By submission to the case file: ABP Case Reference 324164 — Carrow Wind Farm, REDIII Application under SI 274 of 2025

Carrow Wind Farm

An Coimisiún Pleanála — Case 324164

EXECUTIVE SUMMARY OF STRONGEST OBJECTION GROUNDS

Figure 2-1. Noise Monitoring Locations

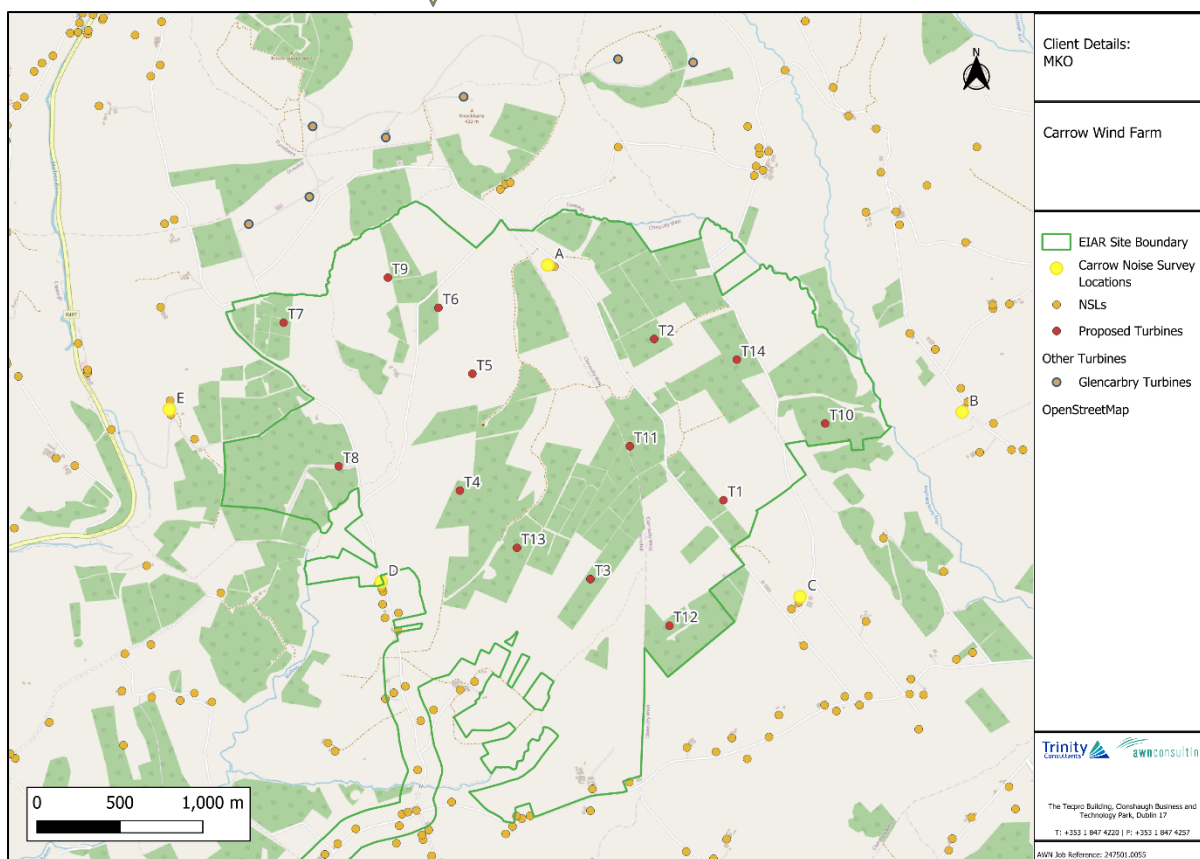
4. No background noise monitor at H150 — nearest monitor H152 is 93 m away: [Appendix 12-3 — Baseline Noise Survey](#) Table 2-1 shows the five survey locations; the closest to H150 (ITM X=596,138; Y=649,561) is Location C at H152 (ITM 596,189; 649,654) — approximately 93 m away. No monitor was placed at H150 itself, despite H150 being the closest dwelling to T12 and appearing in the exceedance tables.

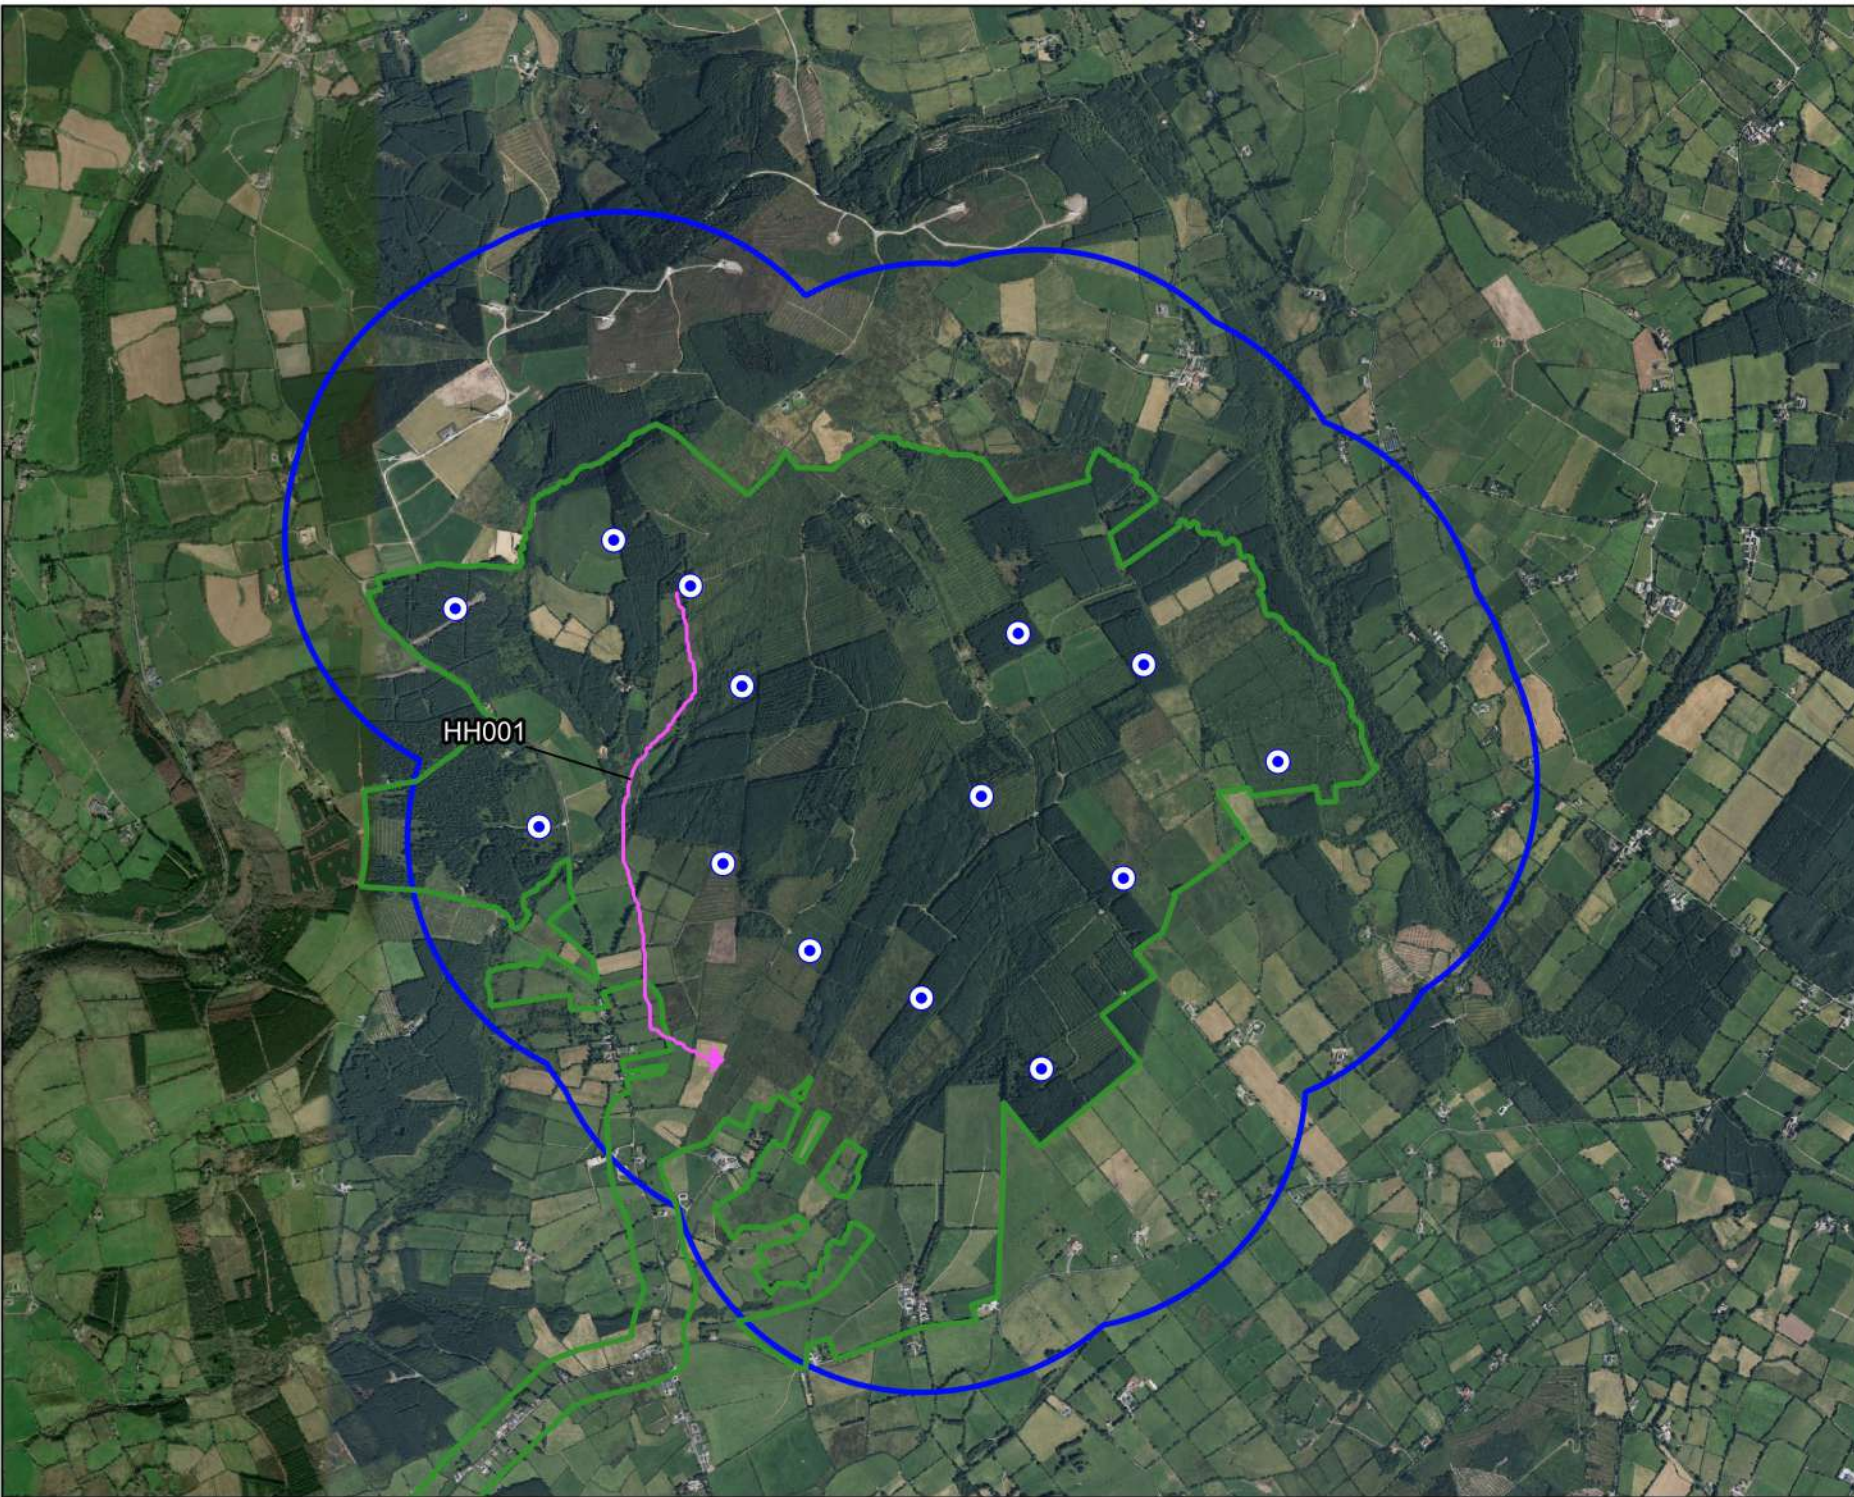
9. Hen harrier observation 100 m from T12; cumulative SPA mortality unquantified: [EIA Chapter 7 – Birds](#) records a hen harrier carrying prey in June 2021 approximately 100 m from the nearest proposed turbine. This flightline passes directly through the T12/T1/T10 corridor. Golden plover and whooper swan were recorded at collision height but excluded from the collision risk model. No cumulative hen harrier mortality estimate exists across the 23 wind farms within the Slievefelim SPA foraging range.
